Application no: **3/2021/0517**

Address: **Lower Abbott House Abbott Brow Mellor BB2 7HU**

Proposal: **Proposed construction of a two-storey extension to the rear.**

The Local Highway Authority have viewed the plans and highway related documents and have the following comments to make:

drawing number
PL.10

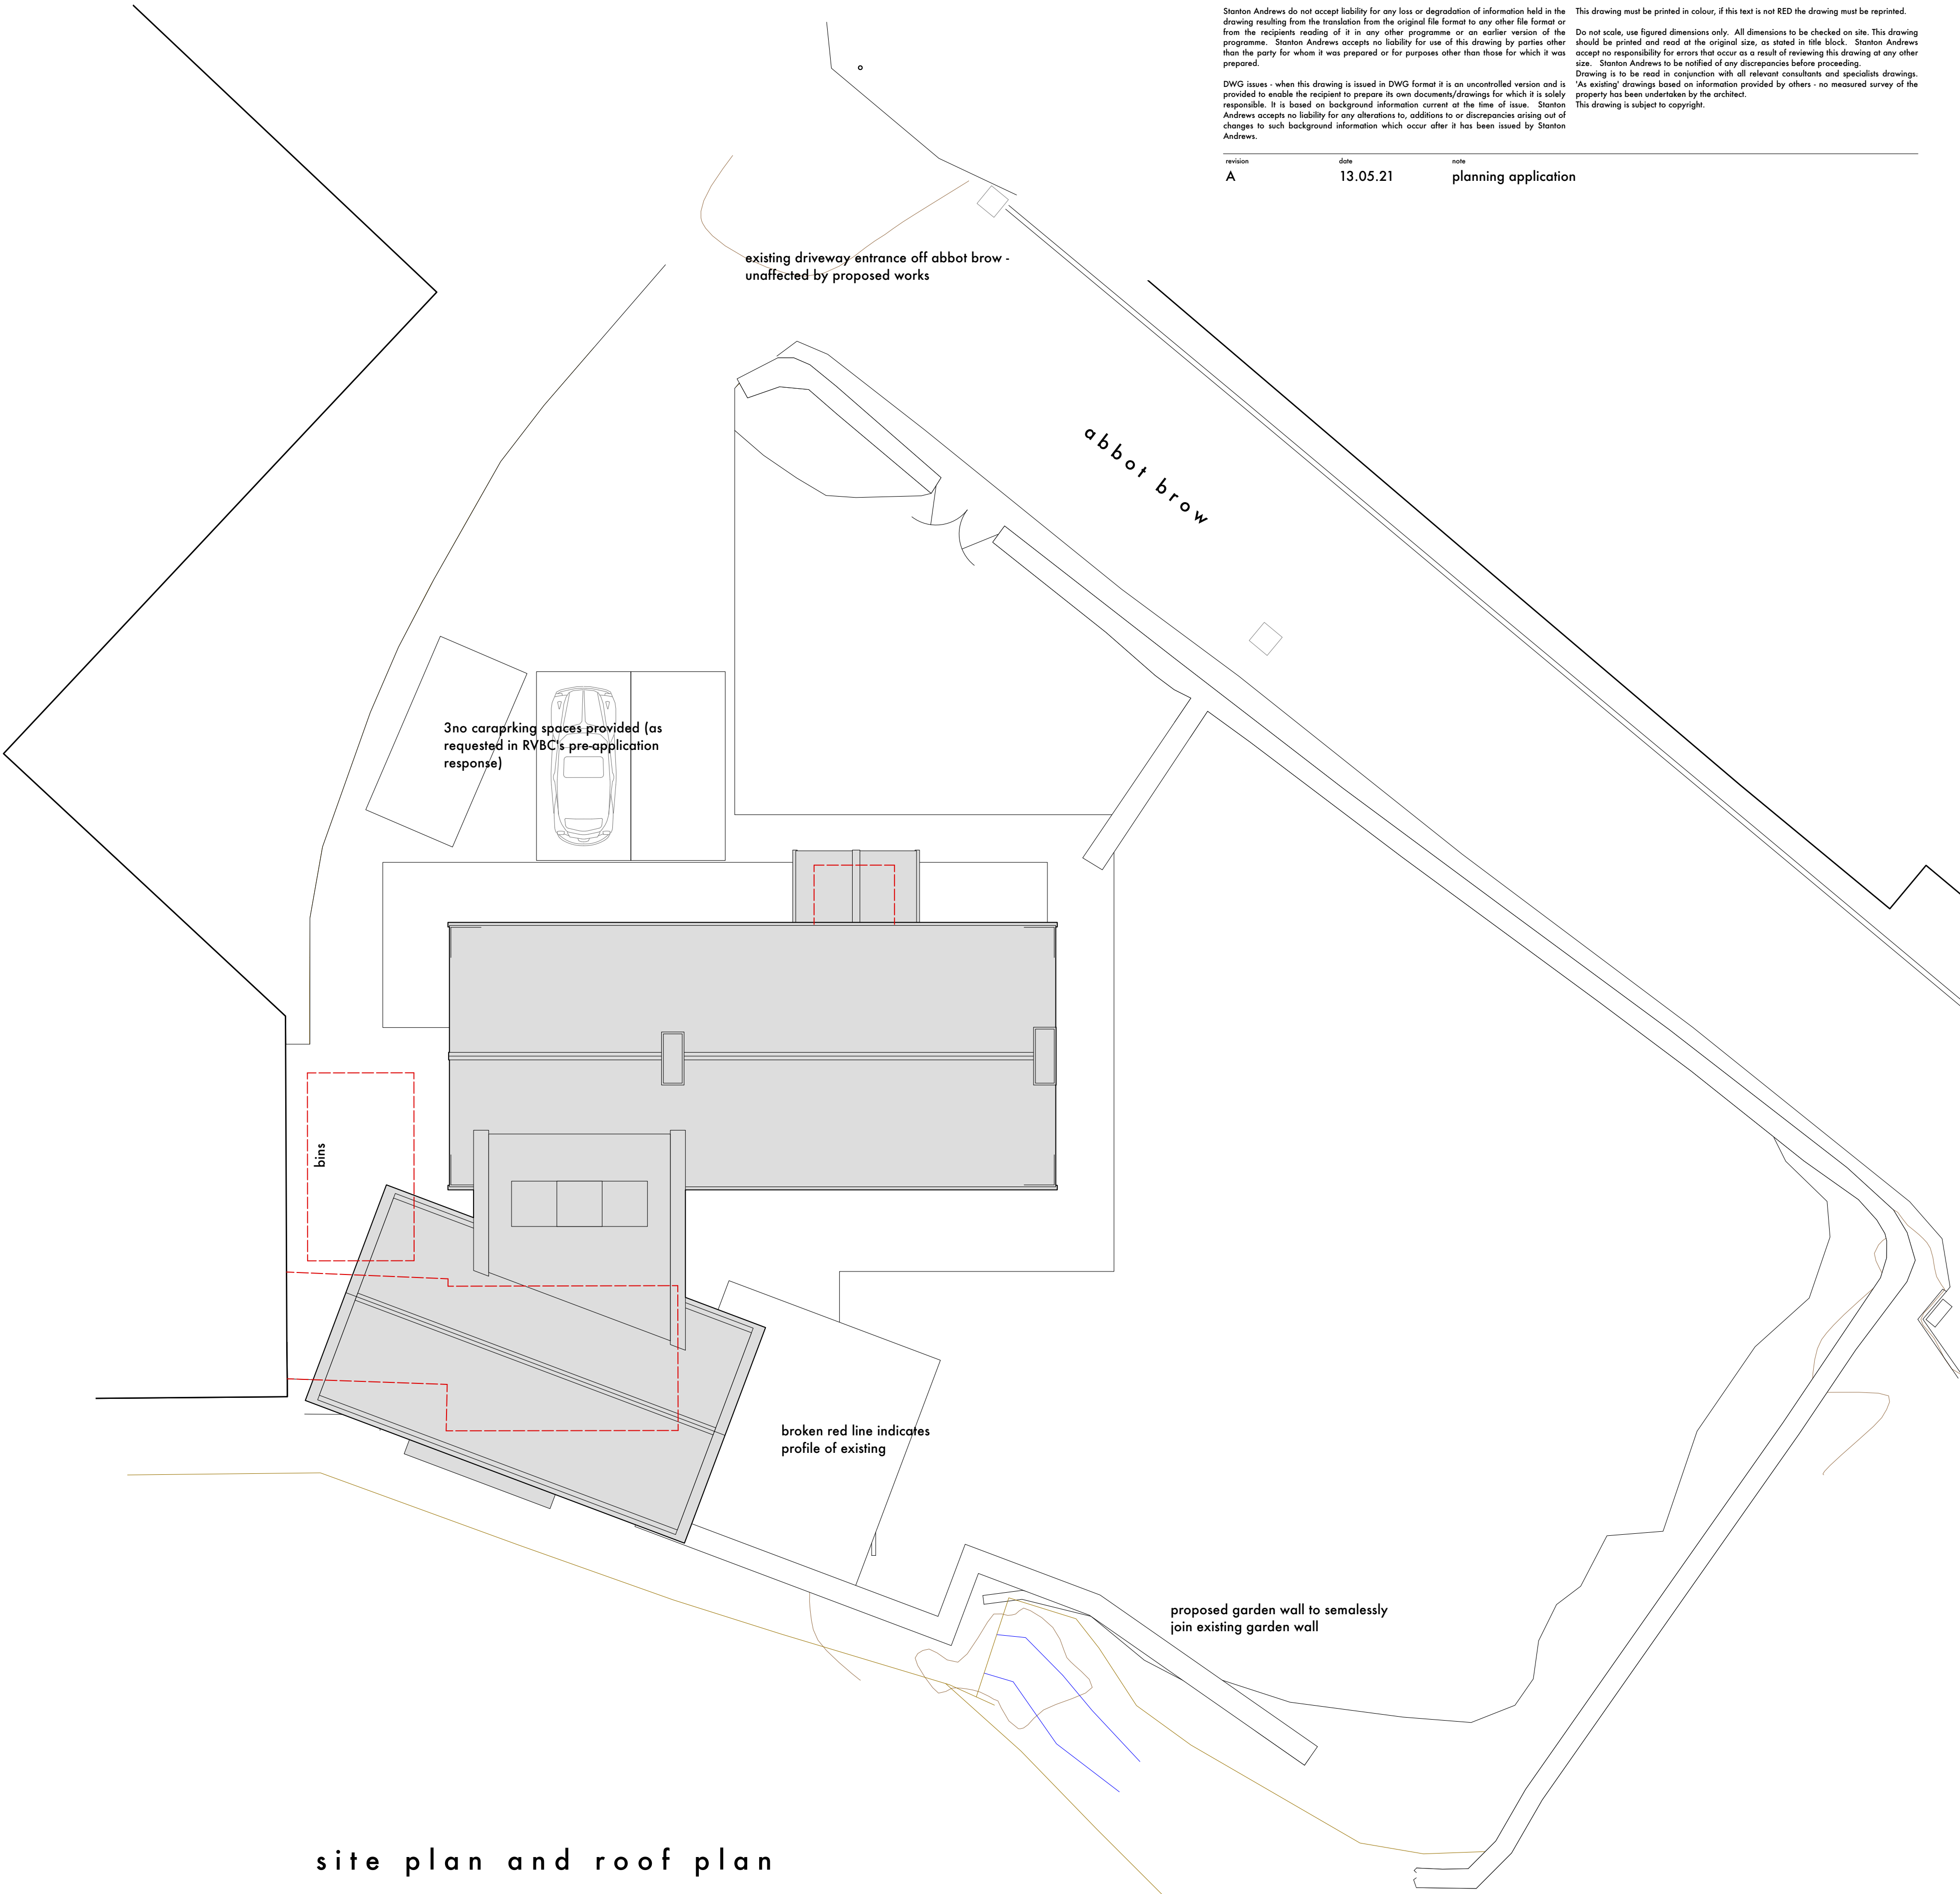
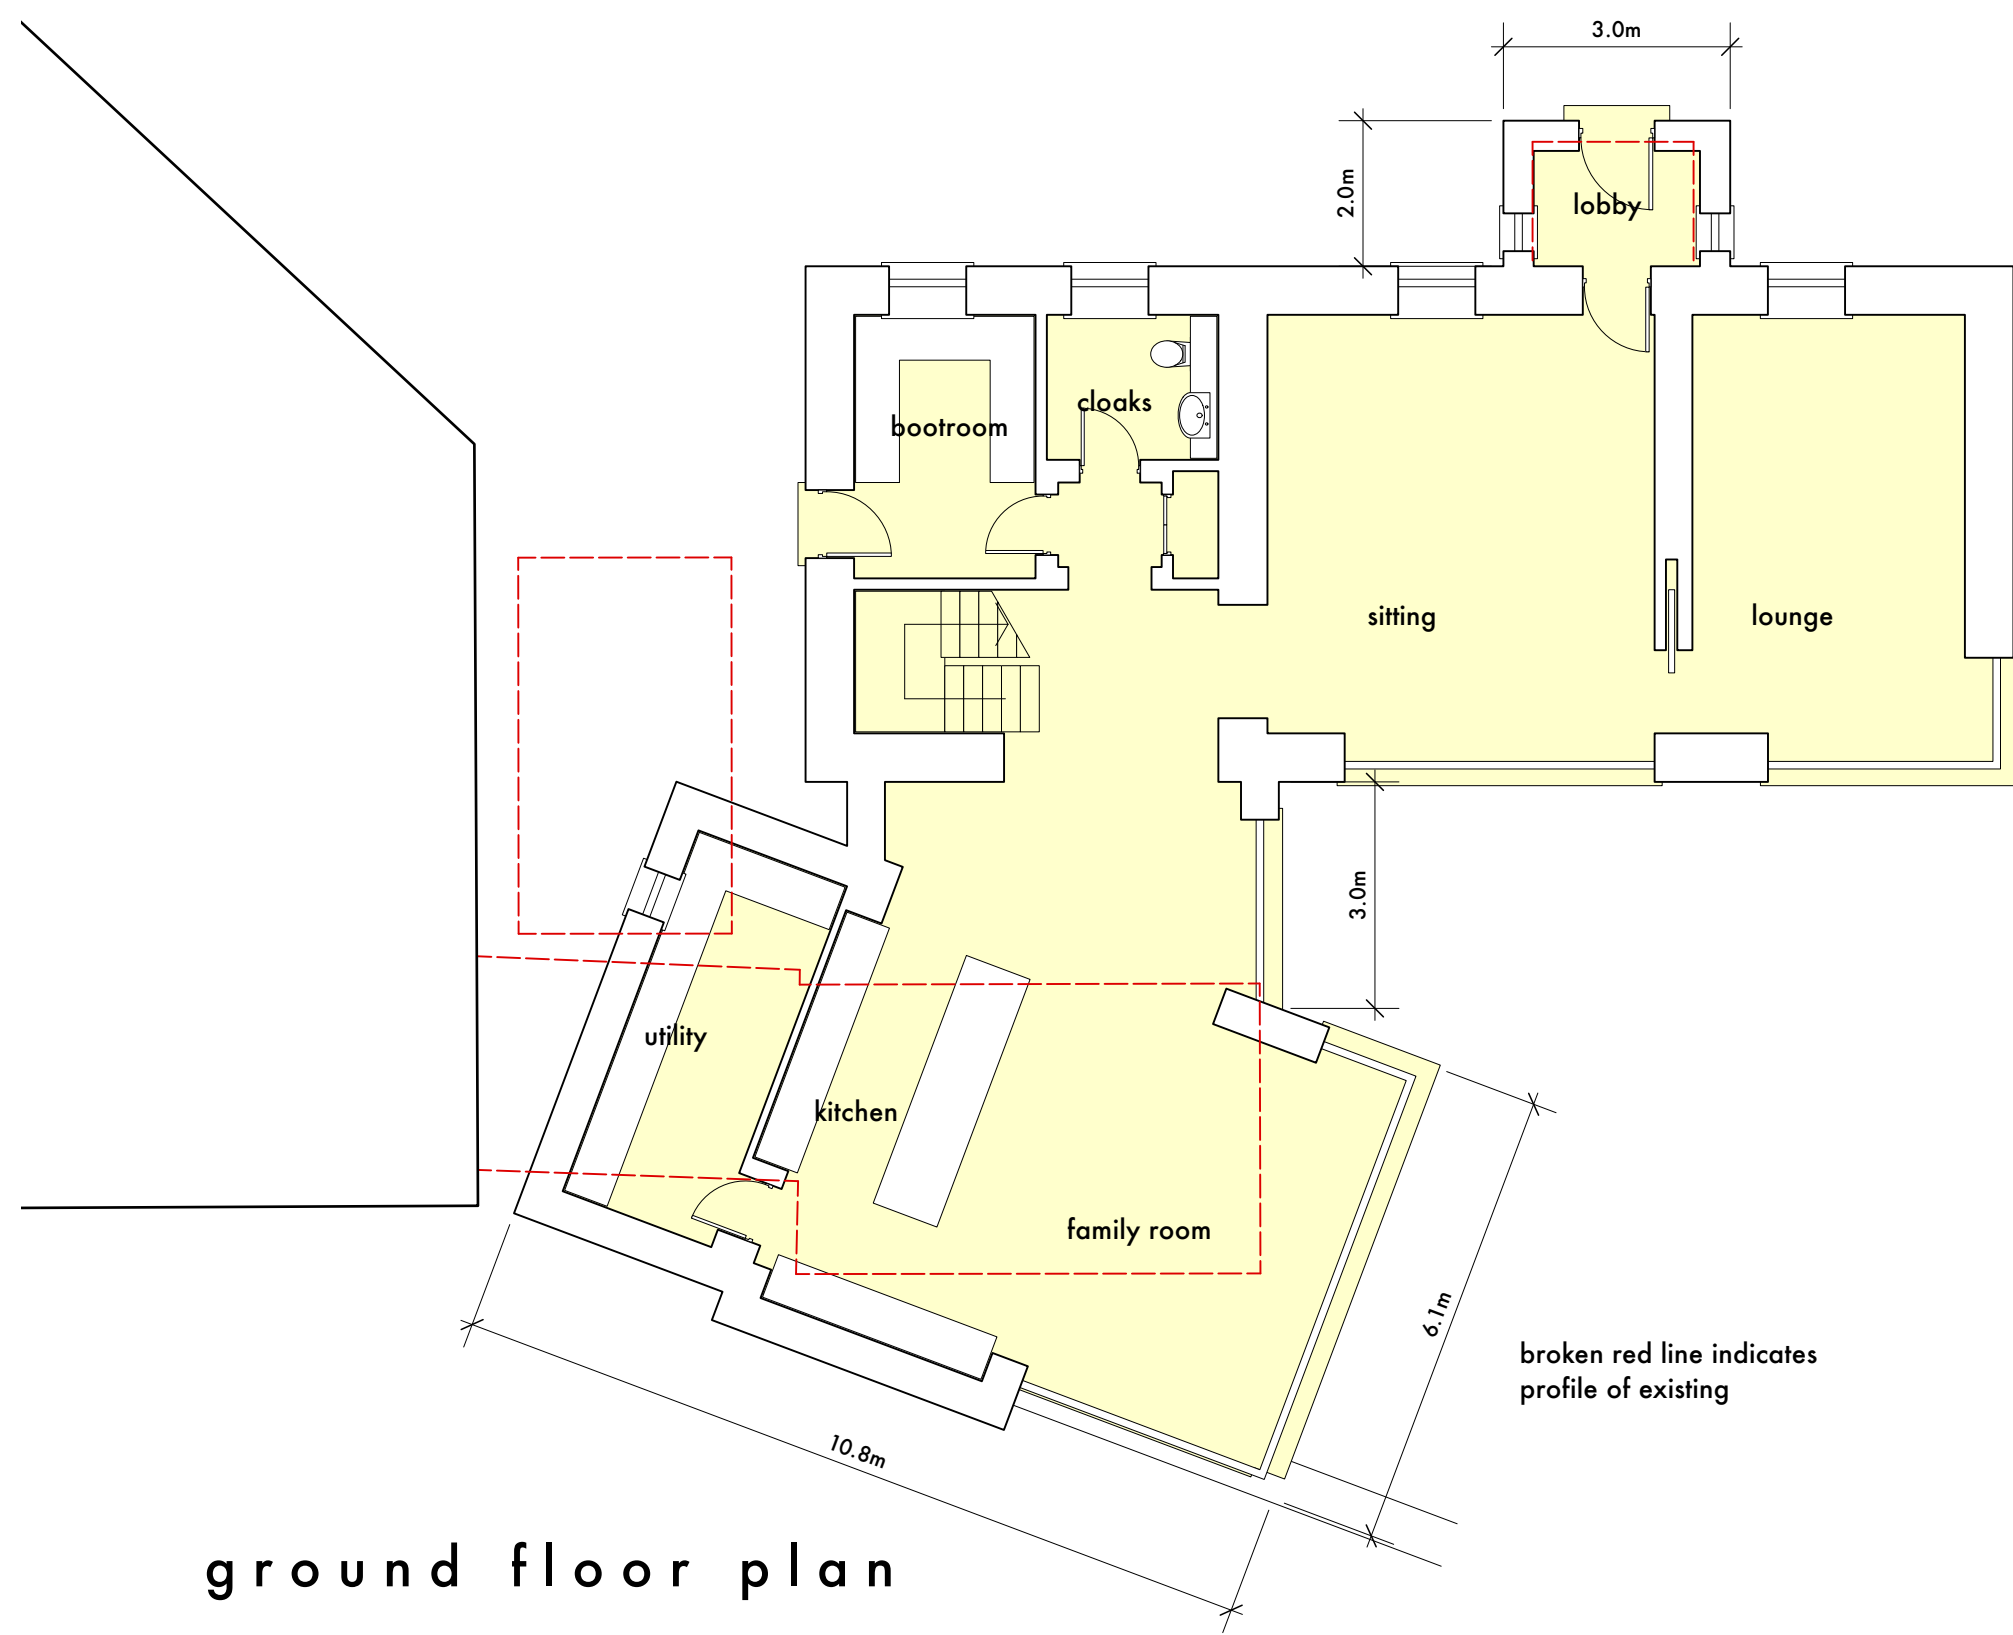
The LHA have reviewed Stanton Andrews Architects drawing number PL10 Rev A titled "Proposed Site Plan and Floor Plans" and understands that the site will provide 3 car parking spaces for the 4-bed dwelling. This complies with the Joint Lancashire Structure Plan and therefore the LHA have no objection to the proposal.

1. The development hereby permitted shall not be occupied until such time as the parking and turning facilities have been implemented in accordance with Stanton Andrews Architects drawing number PL10 Rev A. Thereafter the onsite parking provision shall be so maintained in perpetuity.
